WEST SUSSEX COUNTY COUNCIL CONSULTATION

TO:	Arun District Council FAO:Amber Willard
FROM:	WSCC - Highways Authority
DATE:	20 April 2020
LOCATION:	4 Flansham Park Bognor Regis PO22 6QD
SUBJECT:	FP/51/20/HH Dropped kerb and crossing.
DATE OF SITE VISIT:	n/a
RECOMMENDATION:	Advice
S106 CONTRIBUTION TOTAL:	n/a

Proposed Layout Drawing

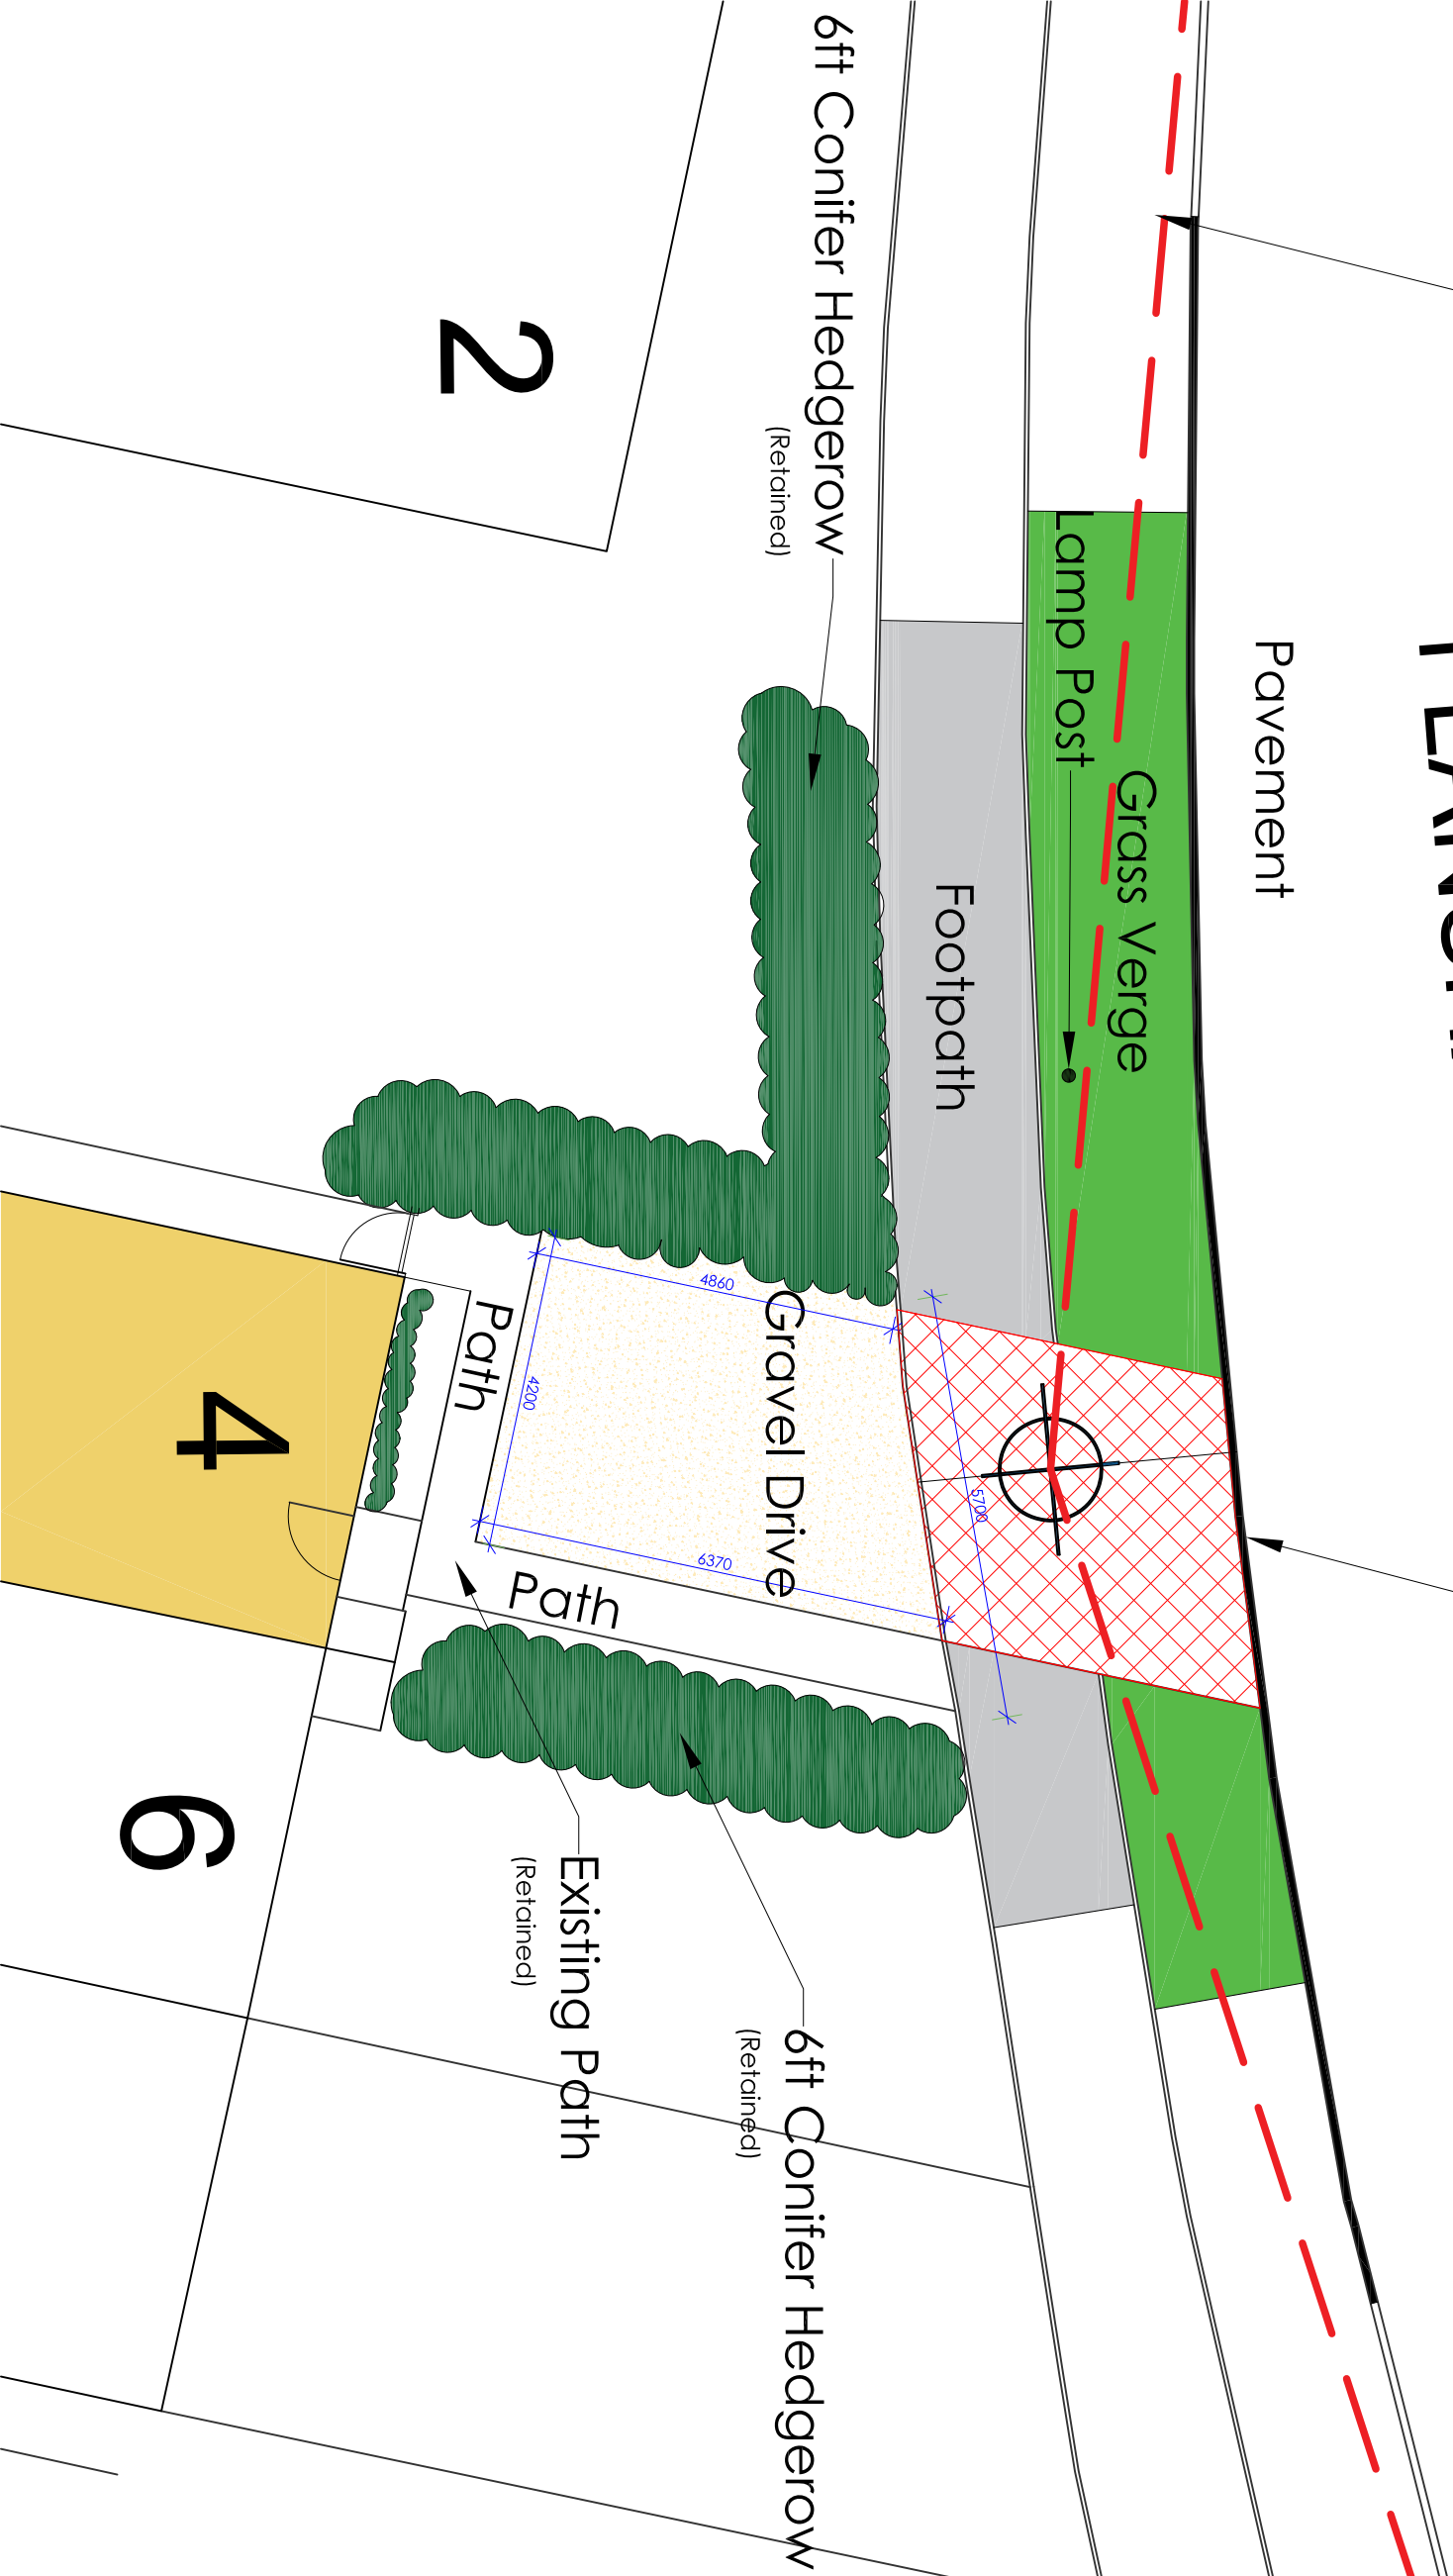
The proposed site plan demonstrates visibility splays at the proposed access, however the full extent of the splays has not been demonstrated. WSCC mapping indicates that visibility splays on both sides of the proposed access is sufficient for the posted speed limit and wholly maintainable within highways land. Data supplied to WSCC by Sussex Police over the period of the past five years, reveals no recorded injury within the vicinity of the site, therefore there is no evidence that the proposed access would exacerbate an existing safety concern.

The proposed VCO, as demonstrated on the proposed site plan (scaled 1:100) is approximately 4.4m wide. Any access works onto the public highways must be implemented under a licence obtained by WSCC to a specification agreed with them.

The driveway is to be constructed from gravel. This may result in material being dispersed onto the public highway affecting the surface of the road. The applicant should provide a gravel trap or area of block paving, or other bound material, at the point of access onto Flansham Park (on land within the applicant's control; not within the publicly maintained highway).

The proposed hardstanding area would be sufficient to accommodate 1 vehicle considering the minimum requirements of 2.4 x 4.8 m (per parking bay) as outlined in Manual for Streets Guidance.

Turn on site would be preferred, however it is evident that this cannot be achieved due to the site constraints. However, other neighbouring properties seem to operate with similar arrangements without any evidence of highway safety concern.

Vehicle parking shall not take place within the site frontage until such time as the vehicular access (including a bound material from the back edge of the Highway boundary to prevent gravel overspill) serving the property has been constructed in accordance with the details shown on the drawing titled 'Proposed Layout' PR/01.
